A46 Newark Bypass

Scheme Number: TR010065

Statement of Common Ground With The Environment Agency

Regulation Number:	Regulation 5(2)(q)
Planning Inspectorate Scheme Reference	TR010065
Application Document Reference	7.21
Author:	A46 Newark Bypass Project Team, National Highways

Figure 10: Slough Dyke realignment – extract from AS-007 (General Arrangement Plans) Sheet 25005

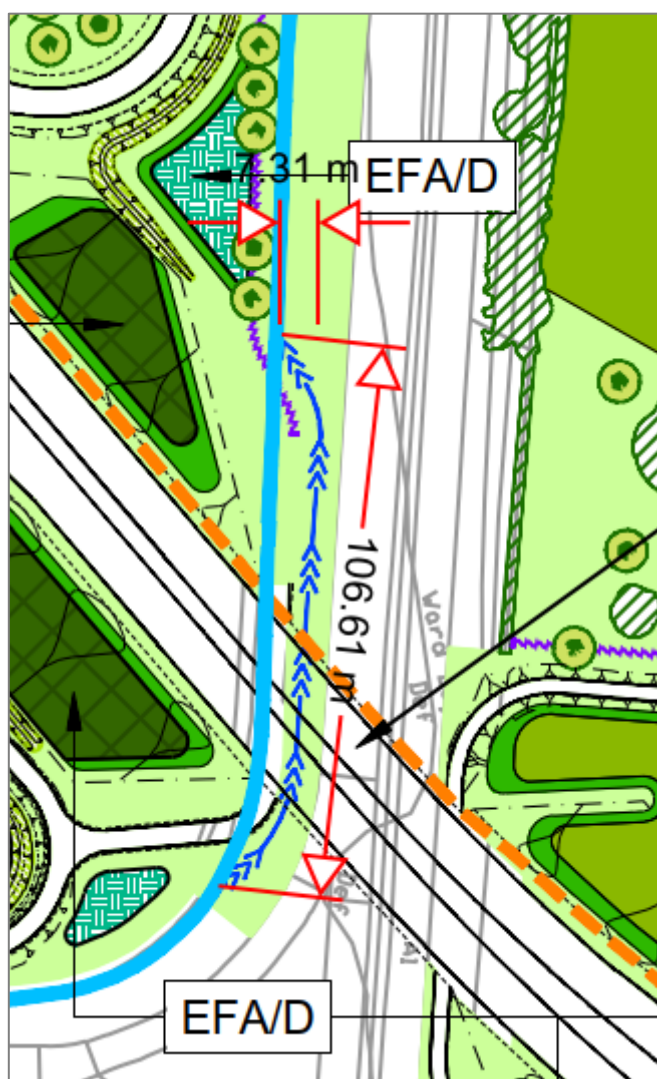
<p>Relevant Representation Reference EAFR-007 (Slough Dyke (main river) realignment) refer to document reference for issue details.</p> <p>No detailed drawings for the Slough Dyke realignment have been provided and the realignment has also not been represented within the hydraulic modelling undertaken.</p> <p>Update at Deadline 2: Within the most recent Hydraulic Modelling Technical Note (as submitted to us for review outside the Examination process), the Applicant has shown that the realignment of Slough Dyke has now been tested within the hydraulic model and confirms no impact on flood risk. No further action is required by the Applicant with regards to testing the Slough Dyke realignment within the hydraulic model. The Hydraulic Modelling Technical Note should be included as appendix of an updated FRA to be submitted as part of the DCO application. While the Applicant has provided sufficient evidence to us to demonstrate that the realignment of Slough Dyke will not have an adverse impact of flood risk, we are still awaiting detailed plans of the proposed river channel in situ. The Environment Agency requires satisfactory cross- sectional plans of the channel and drawings of the channel connecting to the existing channel in order to full resolved this issue. Once a satisfactory revised FRA and plans as mentioned above have been submitted as part of the DCO application, we will be able to resolve this issue.</p> <p>Update at Deadline 4: The Hydraulic Modelling Technical Note as referred to in our WR has now been submitted into the Examination at Deadline 3 [document ref. REP3-034]. This satisfactorily demonstrates that the realignment of Slough Dyke has been tested within the hydraulic model and confirms no impact on flood risk. However, we are still awaiting further detailed plans to clarify the proposed realignment.</p> <p>We acknowledge the Applicant's comments in response to our WR on this issue. However, the issue has since been covered at ISH3 (agenda Item 4 – please see above comments) and note the Applicant intends to provide us</p>	<p>The Applicant welcomes the confirmation that the hydraulic modelling carried out confirms the realignment's hydraulic suitability. All additional flood risk related evidence submitted during the DCO Examination will be appended to the Flood Risk Assessment [APP-177] as appropriate before the closing of the Examination. The Applicant will complete the detailed design of the Scheme following the grant of a DCO for the Scheme. The Applicant has engaged with the Environment Agency regarding the Slough Dyke realignment at flood risk meetings on 05/09/24, 17/10/24 and 27/01/25, providing further details on the proposed plans. On 27/01/25, the draft detailed plans, including a cross-section, for the realignment were discussed with the Environment Agency. At this stage, it is suggested that securing the Environment Agency as a consultee on the design of the Slough Dyke realignment is appropriate. The Applicant welcomes the Environment Agency's further comments on this item.</p> <p>The Applicant has submitted draft detailed design drawings of the Slough Dyke realignment to the Environment Agency who have requested an amendment to the design through the removal of reno mattress and replacement with appropriately sized riprap for erosion control and embankment stability. The updated design will be provided to the Environment Agency who have agreed that this can be submitted as part of the flood risk activity permit application for the Slough Dyke realignment works.</p>	Agreed	19/02/2025
